RE: 4th & Montano Dental Office Grading and Drainage Plan

Engineers Stamp Date 7/6/15 (F14D055)

4TH AND MONTANO DENTAL OFFICE RE: **GRADING AND DRAINAGE PLAN (F14-D055)**

4th & Montano Dental Office Grading and Drainage Plan Engineers Stamp Date 5/14/15 (F14D055)

ENGINEER'S SEAL	4TH ST AND MONTANO DENTAL OFFICE	DRAWN BY DY
		DATE 6/30/15
	GRADING AND DRAINAGE PLAN	2014099-GRE
	RONALD R. BOHANNAN P.E. #7868	 TIERRA WEST, LLC 5571 MIDWAY PARK PLACE NE ALBUQUERQUE, NM 87109 (505) 858-3100 www.tierrawestllc.com
		JOB # 2014099

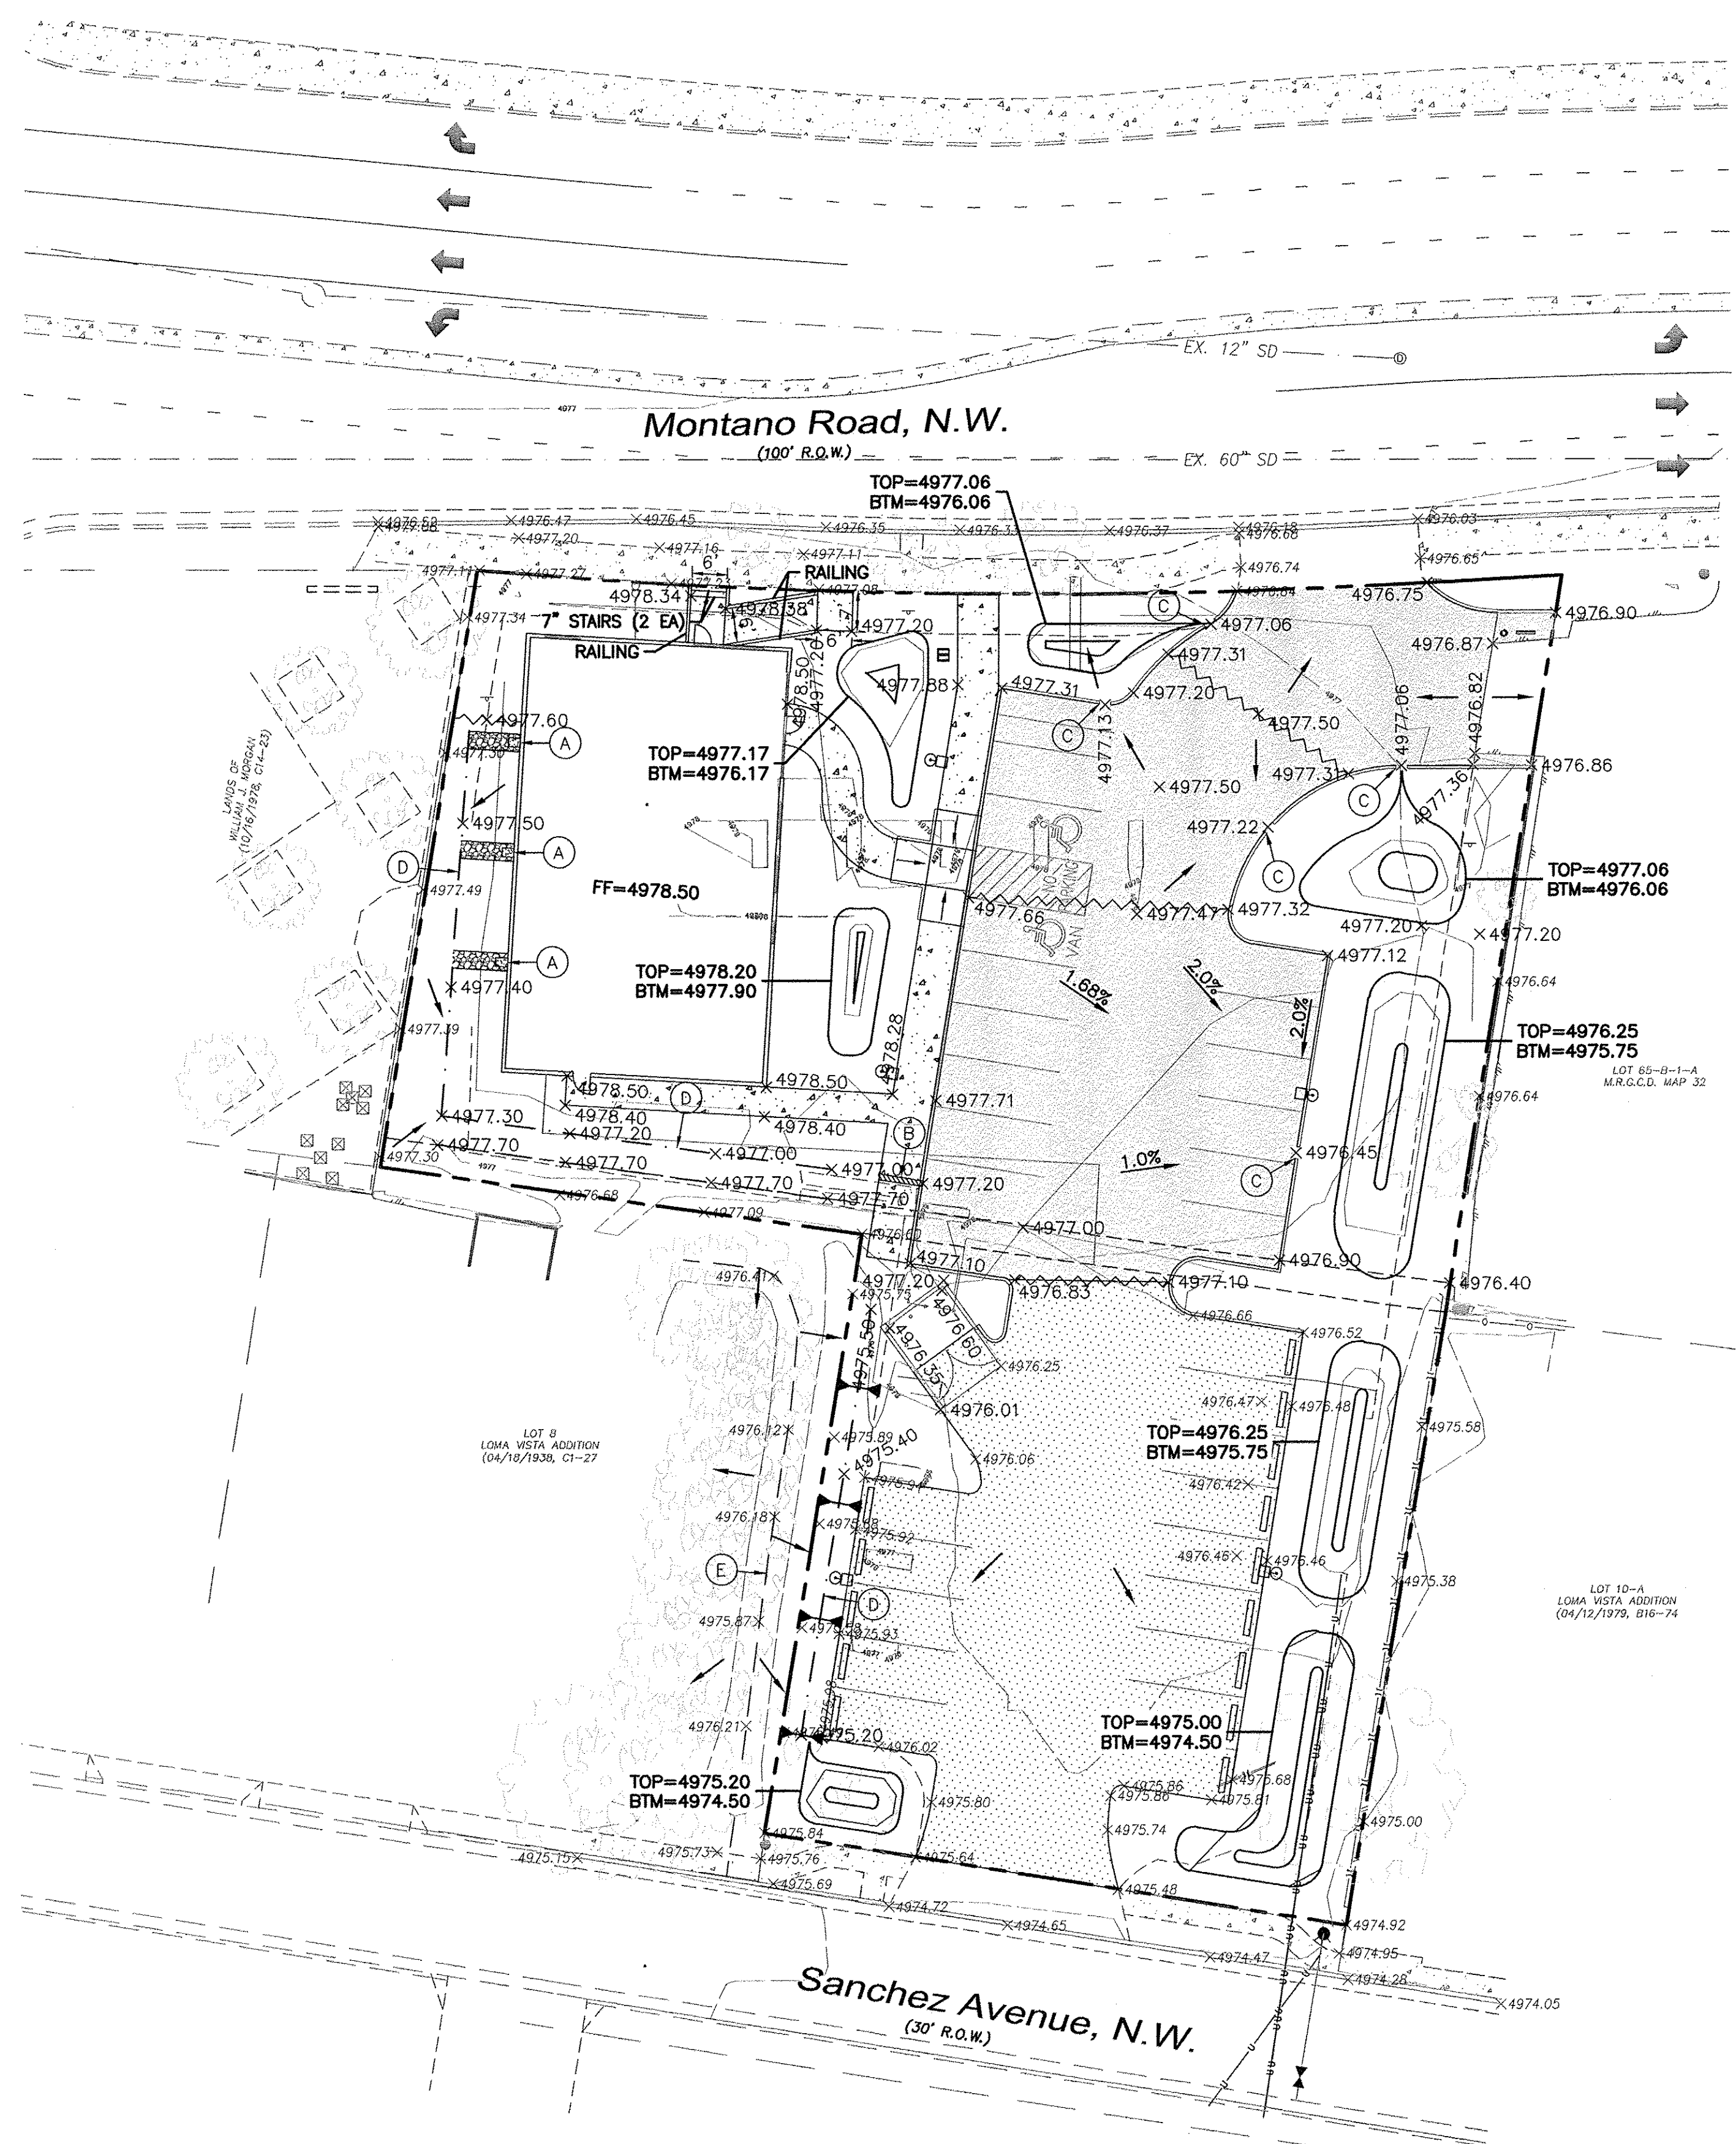
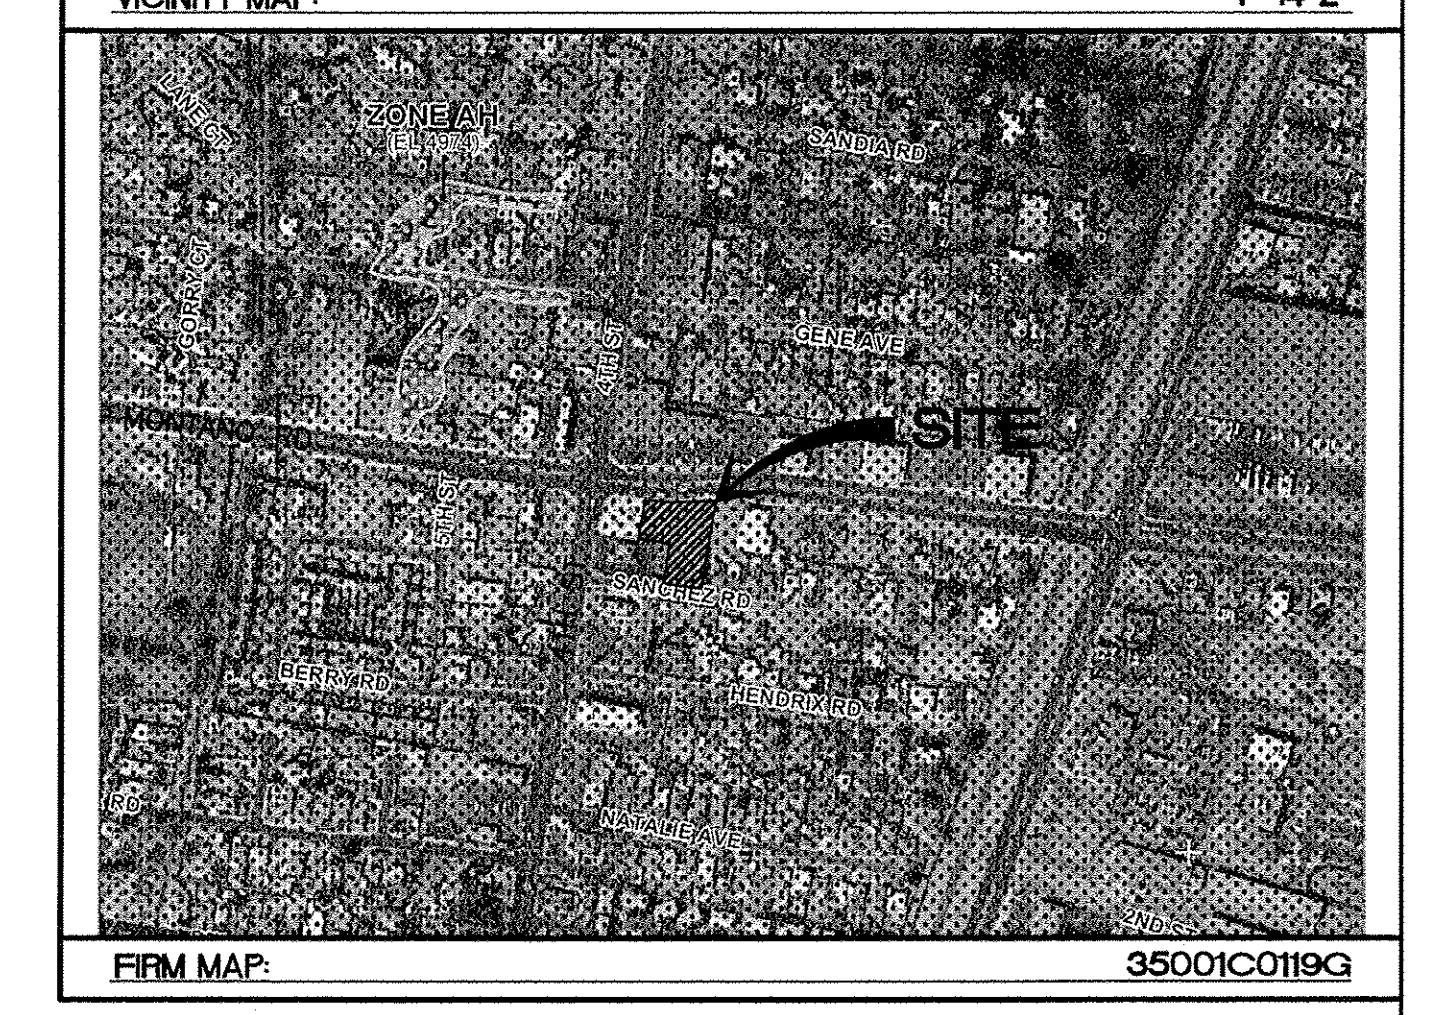
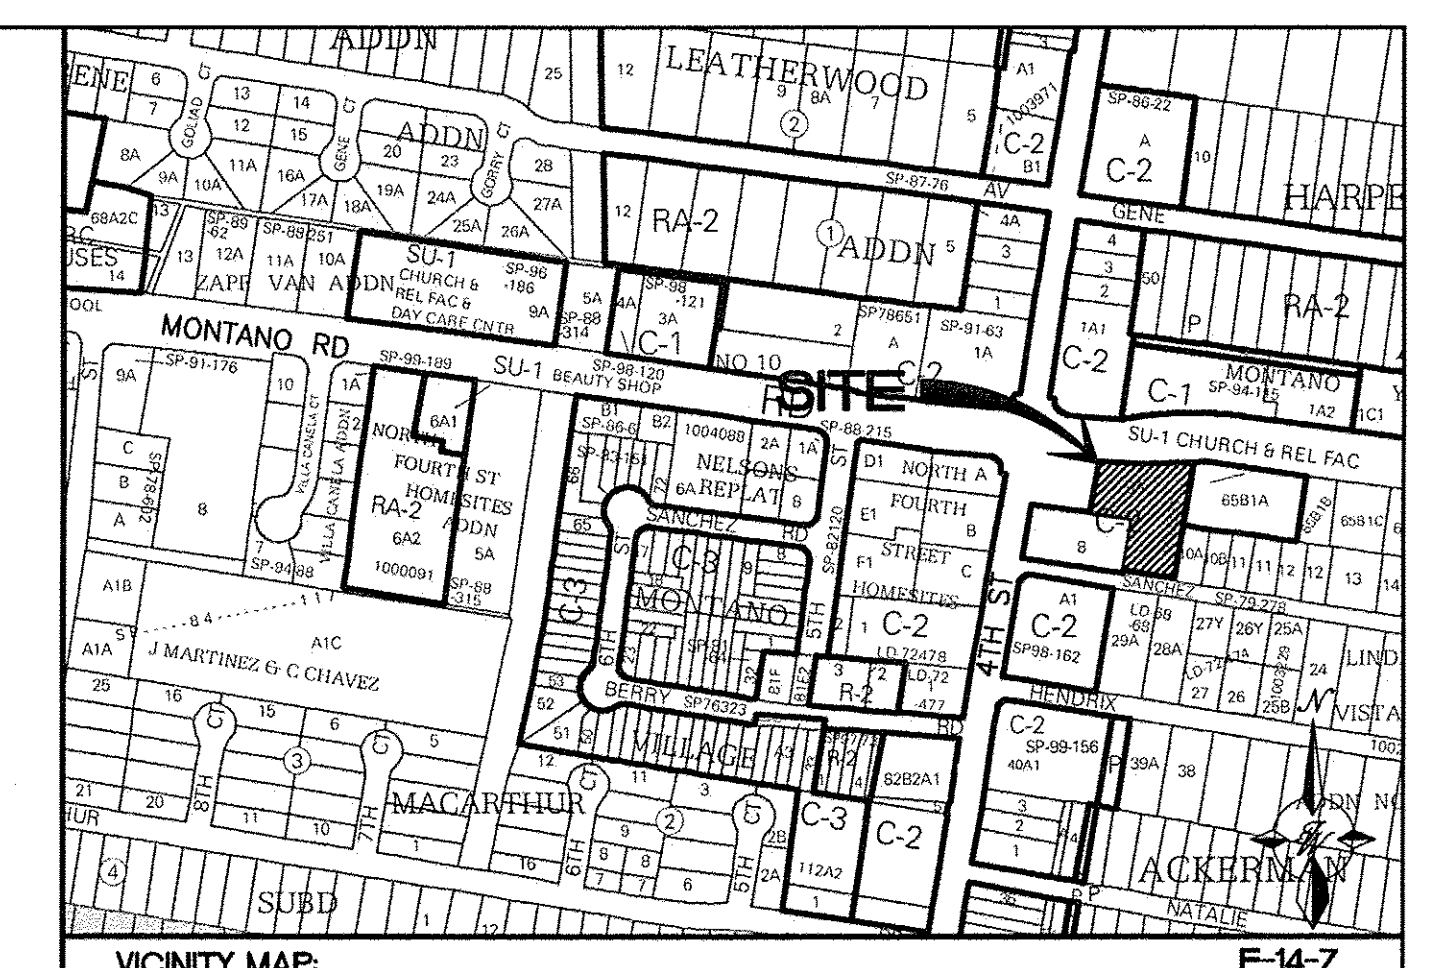
- Are the west and south areas of the building landscaped? Response: Yes they are landscaped.
- A cross lot drainage agreement is needed from the owners to the south. Response: Per discussion with Mr. Rael, additional information was added to the plan to show that a cross lot drainage agreement is not necessary as the drainage is maintained onsite.

- Is curbing in place at the existing south parking area? If so, curb cuts will be needed. Response: No. curbing is not in place in the existing south parking area.

- 4. How are flows from the roof directed away from the building? Response: Flows from the roof are directed to 3 down spouts on the west side of the building. These are indicated on the grading plan along with splash blocks. The runoff is captured in the drainage swale that runs along the west side of the building.

- 5. What is the double line in the north landscaped area? Is this a sidewalk culvert? Response: The double lines are existing contour lines. The sidewalk and concrete area along the north side of the building have been revised per comments from Planning to include a ramp and stair connection to the existing Montano Blvd sidewalk. The remaining area on the north side is now to be landscaped.

4TH ST AND MONTANO DENTAL OFFICE		DRAWN BY
	GRADING AND DRAINAGE PLAN		DY
			DATE
			5/14/15
			2014099-GRE
			SHEET #
			C3
			JOB #
5571 MIDWAY PARK PLACE NE ALBUQUERQUE, NM 87109 (505) 858-3100 www.tierrawestllc.com		2014099

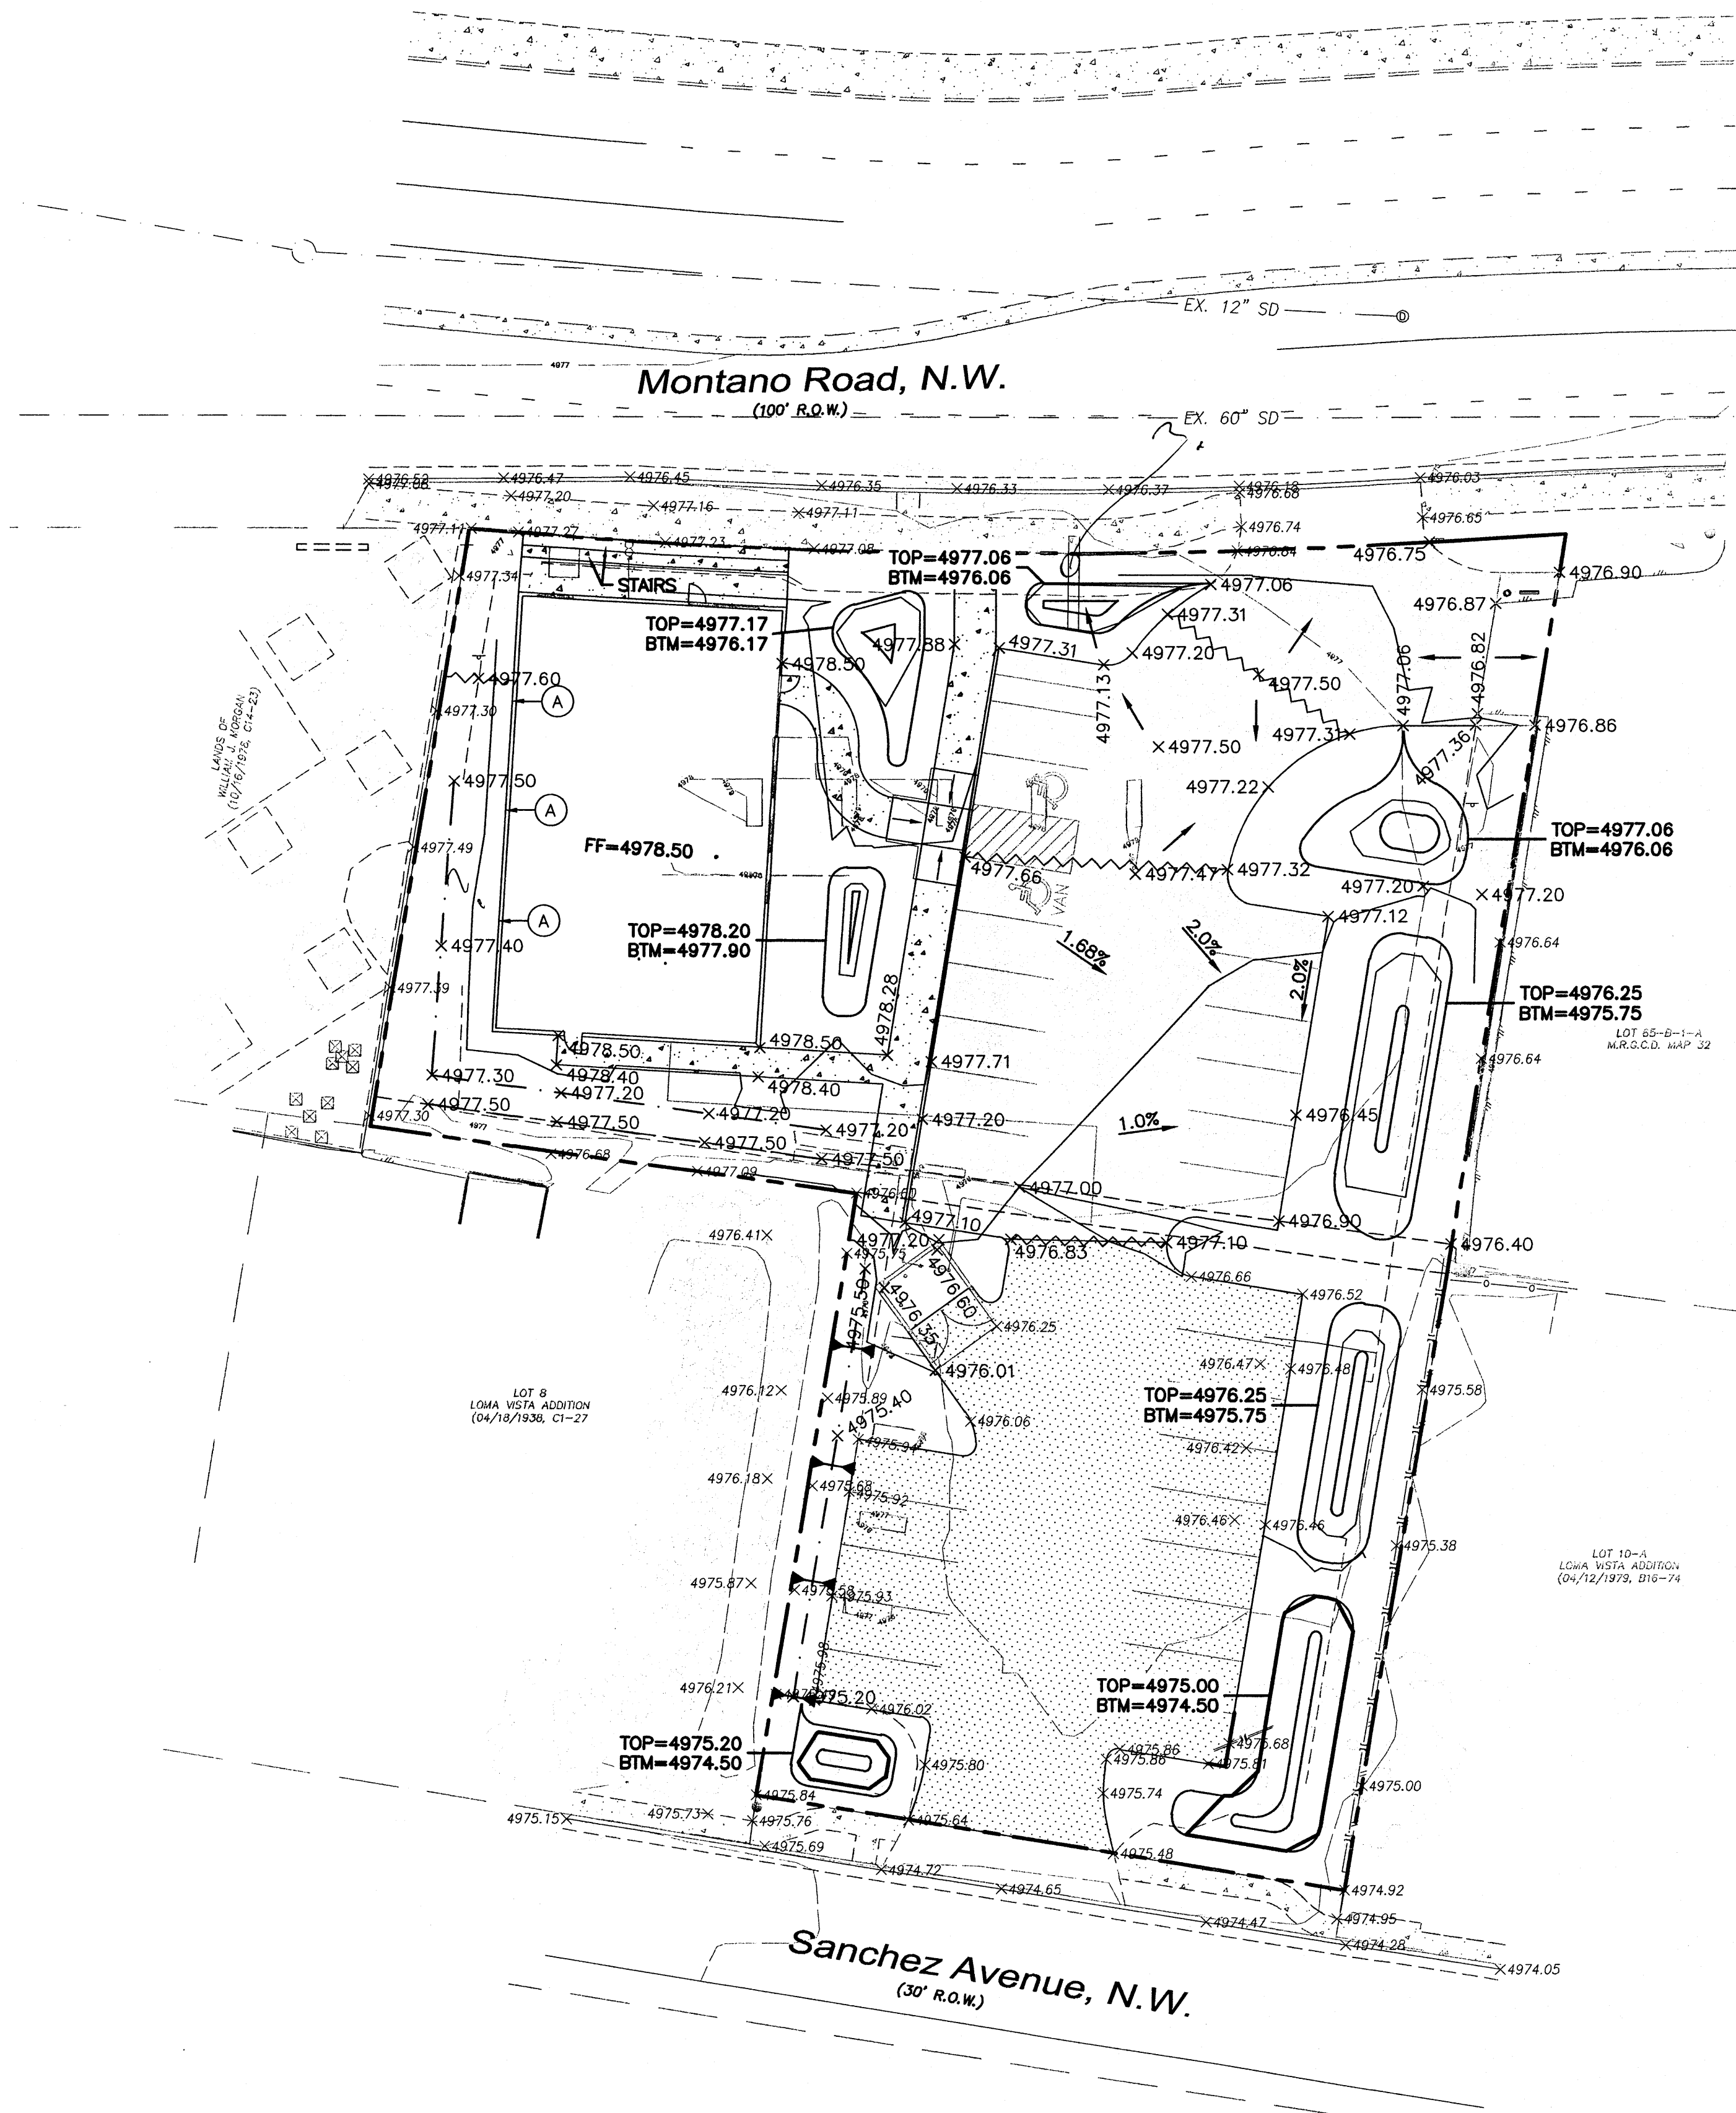
- Are the west and south areas of the building landscaped?
- A cross lot drainage agreement is needed from the owners to the south.
- Is curbing in place at the existing south parking area? If so, curb cuts will be needed.
- How are flows from the roof directed away from the building?
- What is the double line in the north landscaped area? Is this a sidewalk culvert?
